8 September 2022

Project No: 301400263

**RE: Request for Additional Information- Transport Engineering
St Philip's Christian College, Cessnock Campus (SSD-10360337)**

Figure 1: Amended roundabout design, Northrop 2022

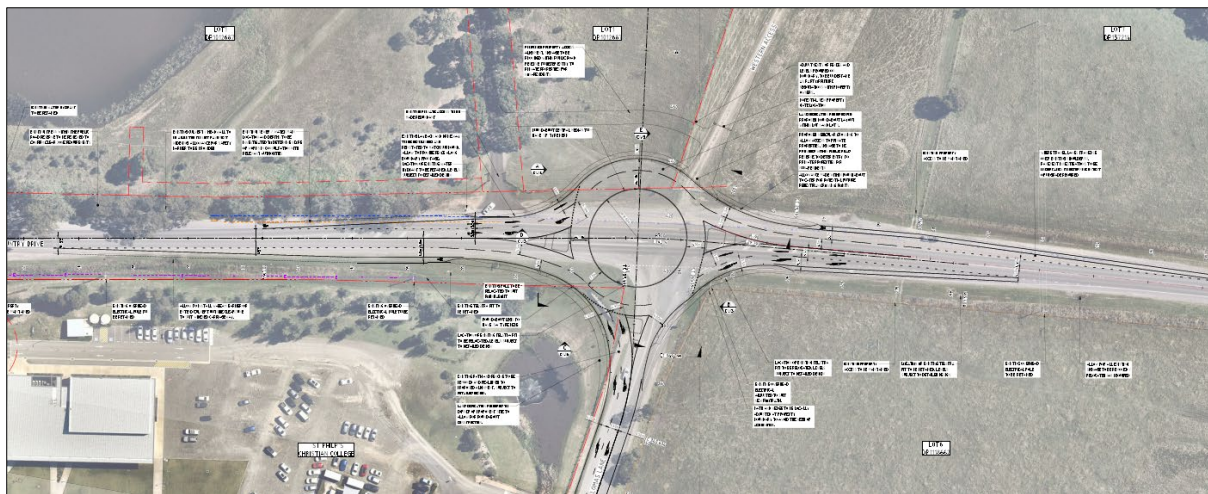
- *a number of surrounding landowners have raised concern regarding existing vehicular (driveway) access on the western side of Wine Country Drive. The TAIA should be revised accordingly (including diagrams) to address these concerns and to ensure that all landowners have continued safe vehicular access to their property.*

- *General design comments on the civil works layout are provided for consideration and will impact upon the scope of the subject development:*
 - *It seems that to achieve the satisfactory LOS indicated in the submitted SIDRA report, the roundabout would require 2 lanes through the roundabout into a merge after the exits in both directions to perform adequately.*

- *The roundabout should consider on road cyclists and pedestrian refuges in the splitter islands*

The roundabout concept design has been revised by Northrop to consider the existing property accesses on the western side of Wine Country Drive. A signalised intersection concept design has also been considered.

We recognise the concerns raised by the surrounding landowners, with the ultimate aim to ensure equal or improved access arrangements as part of any intersection upgrade. Furthermore, the preferred signalised layout at Wine Country Drive/ Lomas Lane intersection provides a better outcome for surrounding landowners, with land acquisition avoided and improved access arrangements provided.

Figure 2: Proposed signalised intersection, Northrop 2022

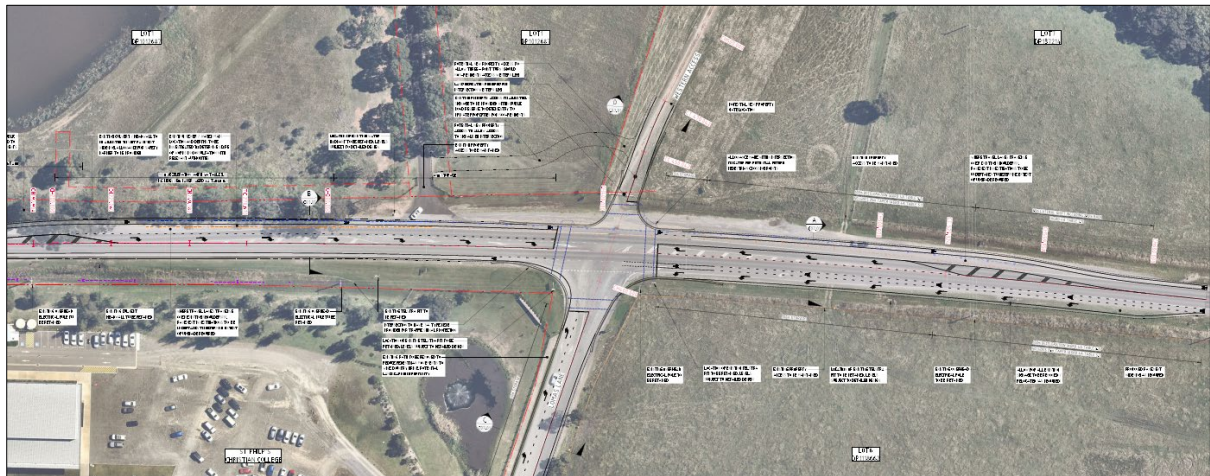
- *Staging of works – The submitted TIA has provided a limited assessment on how the State road network will operate satisfactorily between Stages 1A & 2. Of particular concern is the intersection of Wine Country Drive (WCD) and Lomas Lane, which performs poorly during school peak periods. Even with traffic redistributed via the new southern Wine Country Drive access intersection, it is envisioned that this existing intersection will continue to operate at unsatisfactory levels and present safety concerns for all road users. As a suitable alternative, TfNSW strongly suggests bringing forward the construction of the new roundabout at this intersection from Stage 2 to Stage 1A.*

This comment is noted and agreed. As noted above the preferred intersection configuration is to signalise the intersection of Wine Country Drive/ Lomas Lane with such works intended to be completed as part of Stage 1B.

As detailed above, traffic signals are the preferred intersection layout. SIDRA Intersection modelling was completed for the signalised concept intersection layout, including 2031 traffic volumes (1.5 per cent background growth applied) with additional school traffic generated by the 1,732-student population and associated staff. On this basis, the proposed signalised intersection is expected to operate at LOS B in both the AM and PM peak half hour periods. From an operational perspective, the layout can adequately cater for future traffic volumes, with minimal delays and queuing on all approaches.
